**Colorado Springs, CO
Planning and Development**

Final Report - Corrections Required
Application No. DEPN-23-0002

Description : proposing to build (4) 3-story apartment buildings with clubhouse and pool

VETERANS VICTORY - LOT 1 DEVELOPMENT PLAN

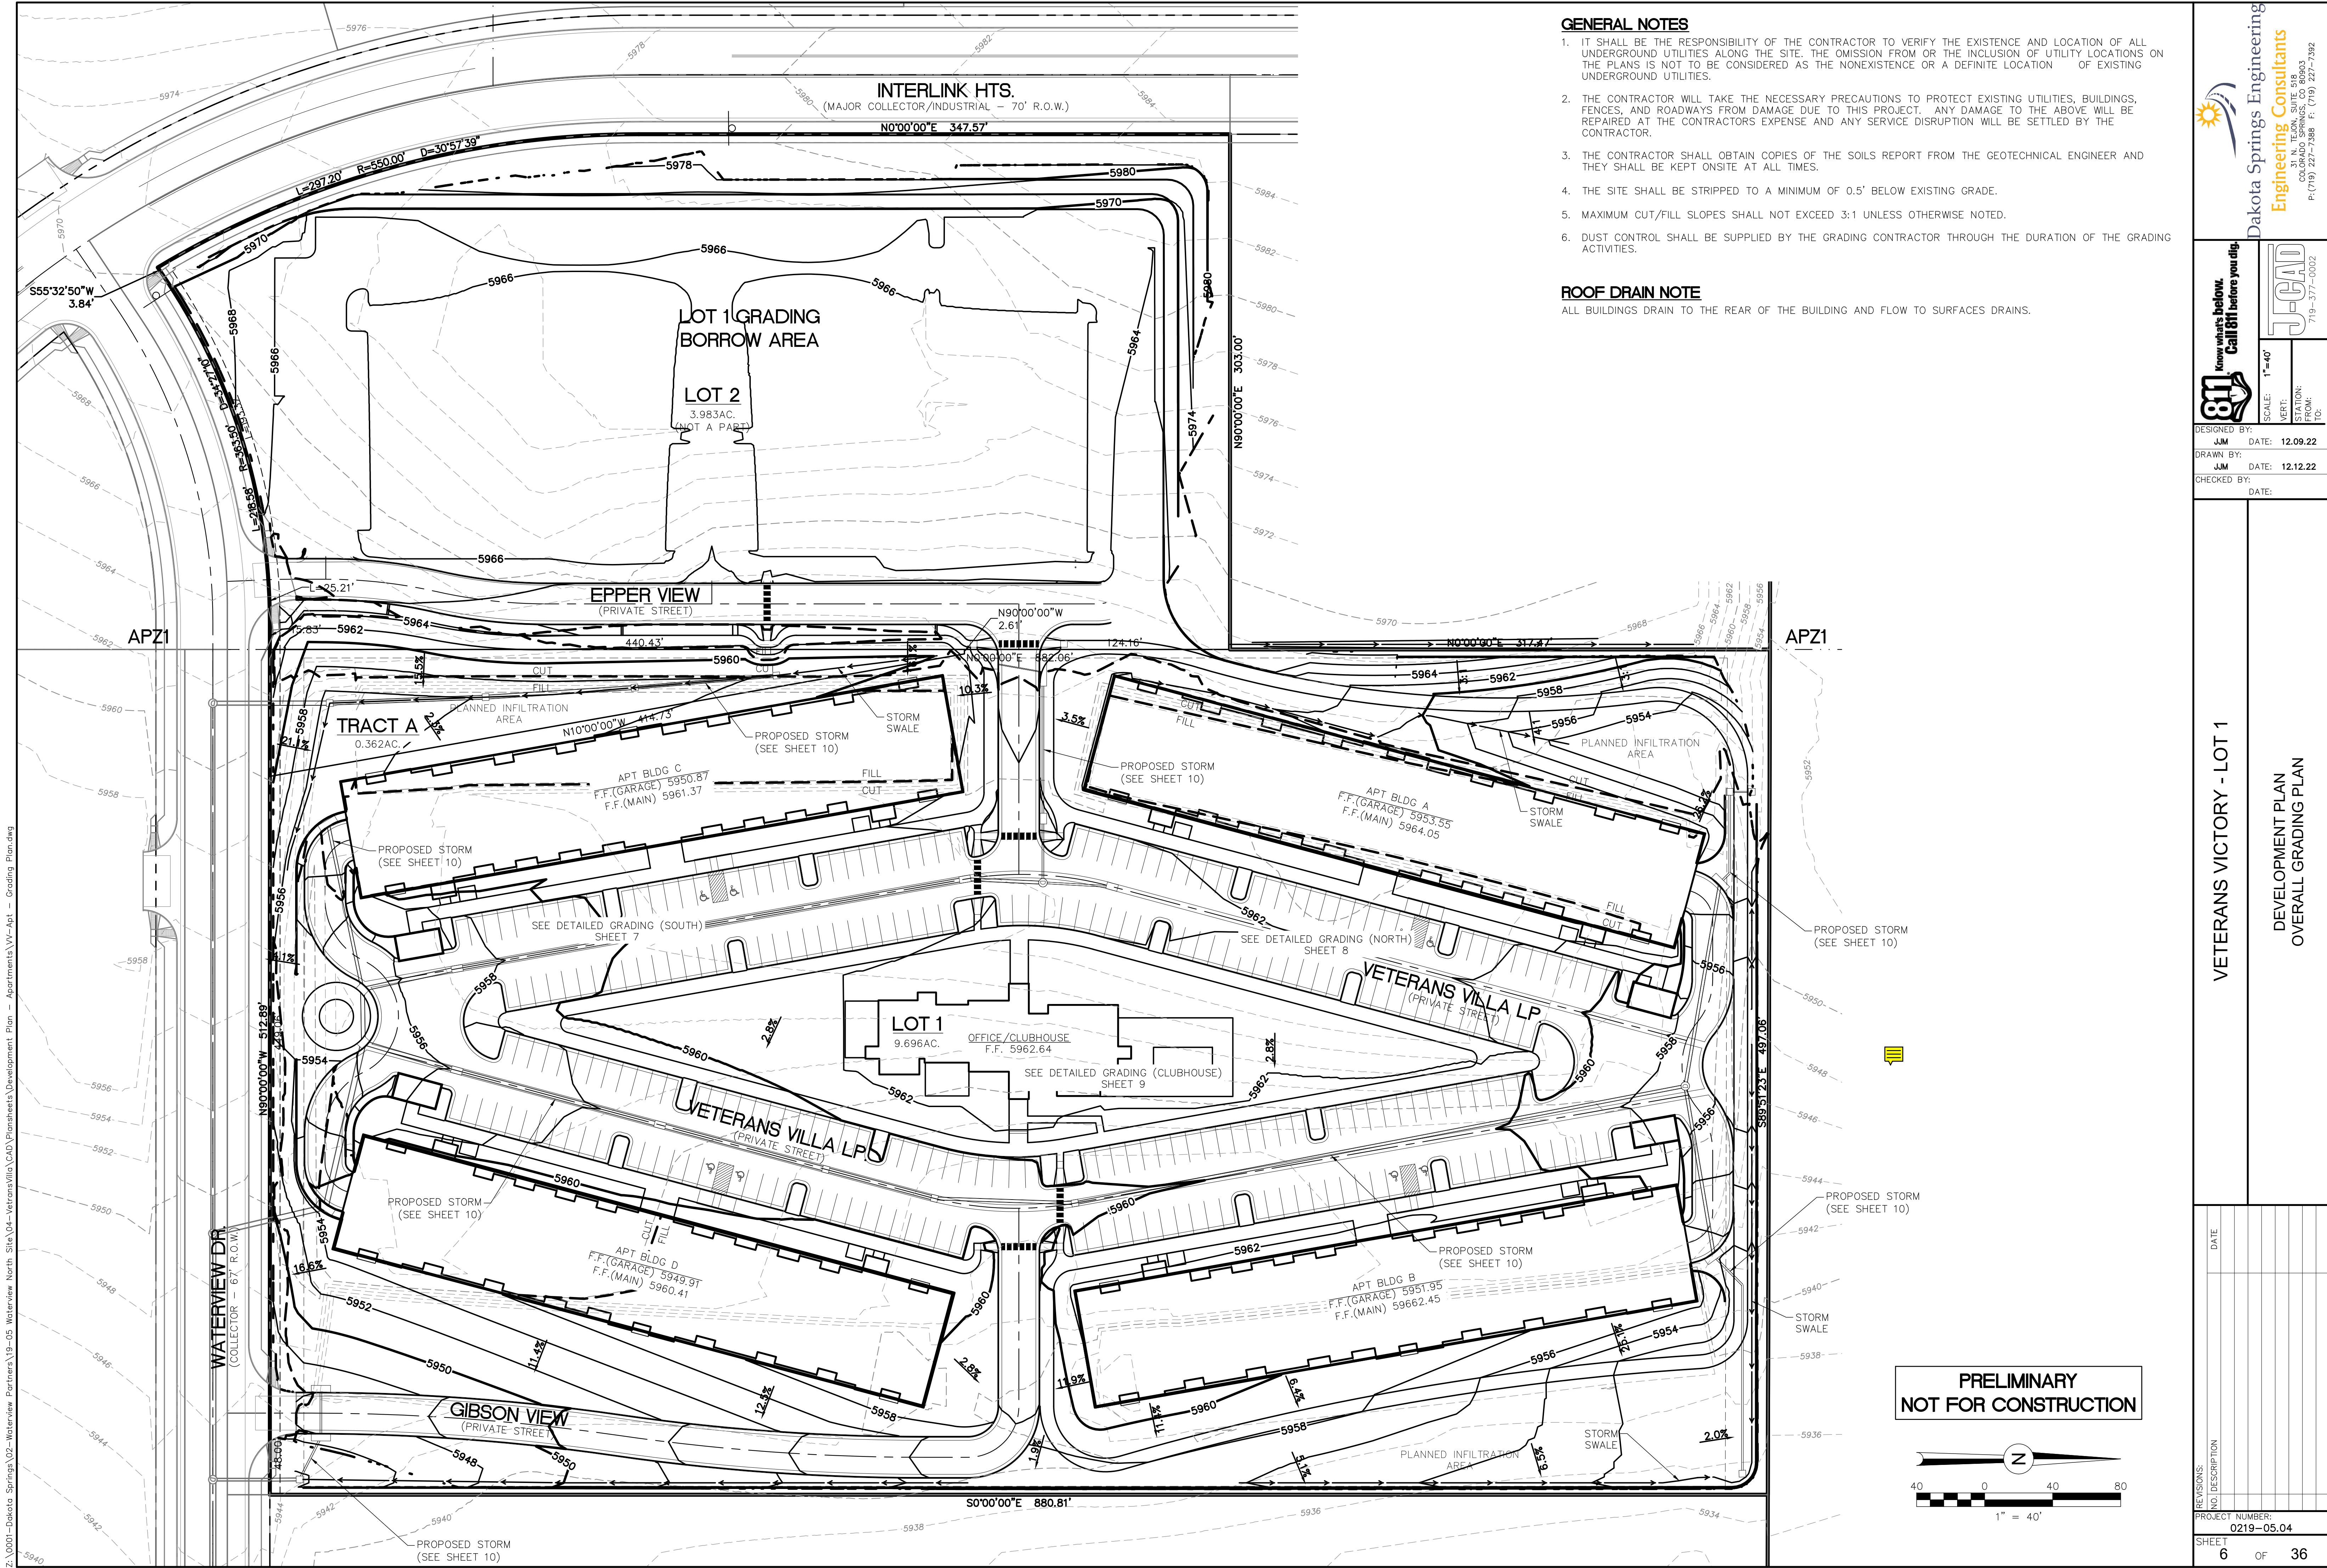
64	13	TJ Gajda : City Engineering - SWENT	Is there a swale to get flows to go to this inlet?
50	14	TJ Gajda : City Engineering - SWENT	Label swales (all)
6	4	Patrick Morris : City Engineering Dev Review	This development is required to fully construct Legacy Hill Drive from Bradley Road to the northern property line. Update the development plan to show Legacy Hill Drive and the Bradley Road/Legacy Hill Drive intersection
7	4	Patrick Morris : City Engineering Dev Review	Include a street cross-section for the public 80' ROW collector Legacy Hill Dr. and plat the entire 80' public ROW.
8	4	Patrick Morris : City Engineering Dev Review	Include a street cross-section for the residential street. Plat the entire 50' ROW and fully construct A Street
9	4	Patrick Morris : City Engineering Dev Review	Label as "Private"
10	4	Patrick Morris : City Engineering Dev Review	label as "private"
11	4	Patrick Morris : City Engineering Dev Review	Call out all the proposed public ROW improvements on the development plan. All public improvements shall follow City Engineering and Traffic Engineering standards.

4	8	Patrick Morris : City Engineering Dev Review	Traffic Engineering cross-section for a collector is 67" ROW with 2 6' eaeements
26	9	Corey Masoumi : Col Springs Utilities	Before reviewing this project, Utilities Development Services needed more information. This region is not currently annexed to the city of Colorado Springs. We are, however, aware of the annexation process. However, no Springs Utilities infrastructure, including wet and dry utilities, exists surrounding this area. As a result, more work is required before we can even begin to review this DP.
27	9	Corey Masoumi : Col Springs Utilities	At this point, requesting HGL and WWMFF will be beneficial, and please include that this parcel will be included in the "Villages at Waterview Annexation." Submit "Hydraulic Grade Line" and "Wastewater Master Facilities" forms; see the following links: https://www.csu.org/Documents/HydraulicGradeLineRequest.pdf https://www.csu.org/Documents/WastewaterMasterFacilityForm.pdf

72	1	Gabe Sevigny : Planning	Please clarify, the only, the only submitted document was the Environmental Assessment, which does not constitute a geological hazard study as the information required did not included a soils test as indicated on the document
66	4	Gabe Sevigny : Planning	Be sure the swale will not negatively impact the ADA spaces and the mx slope of 2% at the back end
70	4	Gabe Sevigny : Planning	Where is the mail kiosk located? Inside the office/clubhouse? if not please depict where to be located to determine access/parking
73	4	Gabe Sevigny : Planning	Provide a hatch sidewalk anywhere a pedestrian needs to cross

PROJECT NUMBER: **0219-05.04**  
 SHEET **6** OF **36**

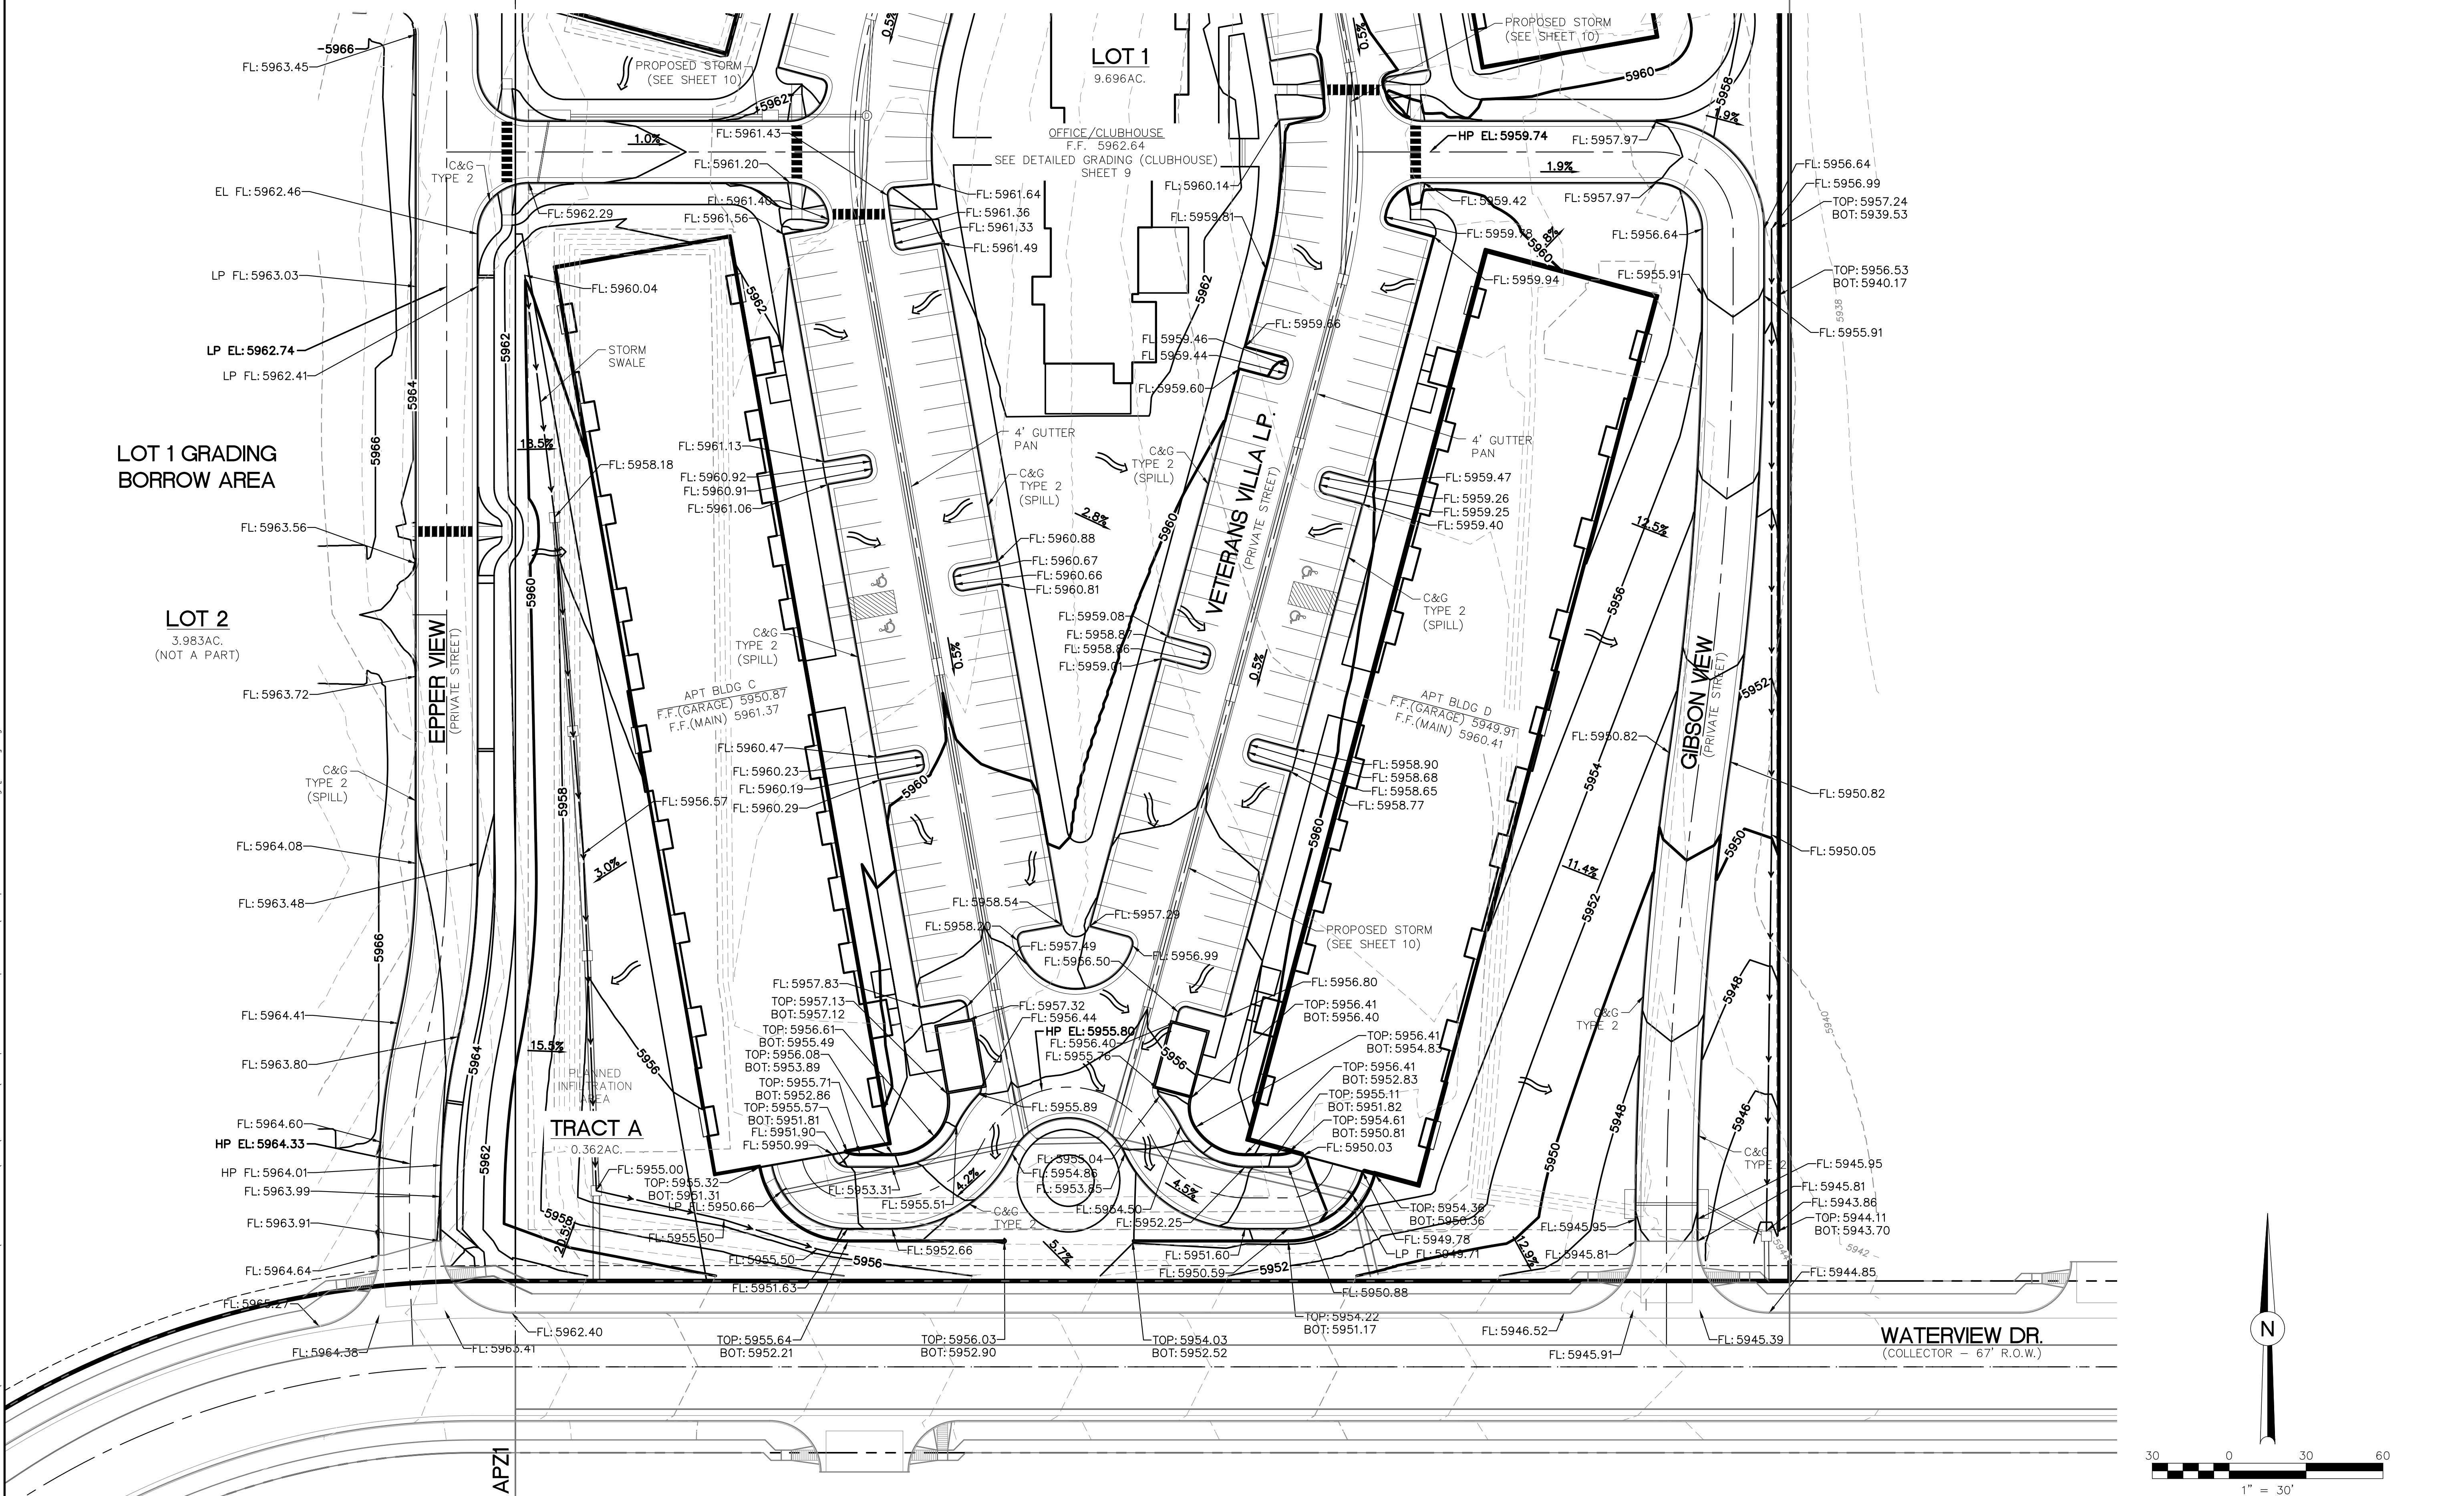
55	5	TJ Gajda : City Engineering - SWENT	Please show pipe infrastructure (pipes, MH, inlets) on grading sheets. It can be labeled on other sheets, but needs to be shown here.
47	6	TJ Gajda : City Engineering - SWENT	Please show pipe infrastructure (pipes, MH, inlets) on grading sheets. It can be labeled on other sheets, but needs to be shown here.
58	6	TJ Gajda : City Engineering - SWENT	Any trash enclosures cannot be placed this close to stormwater inlets. Please move any enclosures that are near an inlet.
61	6	TJ Gajda : City Engineering - SWENT	Label swales (all)
56	7	TJ Gajda : City Engineering - SWENT	Please show pipe infrastructure (pipes, MH, inlets) on grading sheets. It can be labeled on other sheets, but needs to be shown here.
62	7	TJ Gajda : City Engineering - SWENT	Please show pipe infrastructure on grading sheet. It can be labeled on other sheets, but needs to be shown here.
63	7	TJ Gajda : City Engineering - SWENT	Label swales (all)
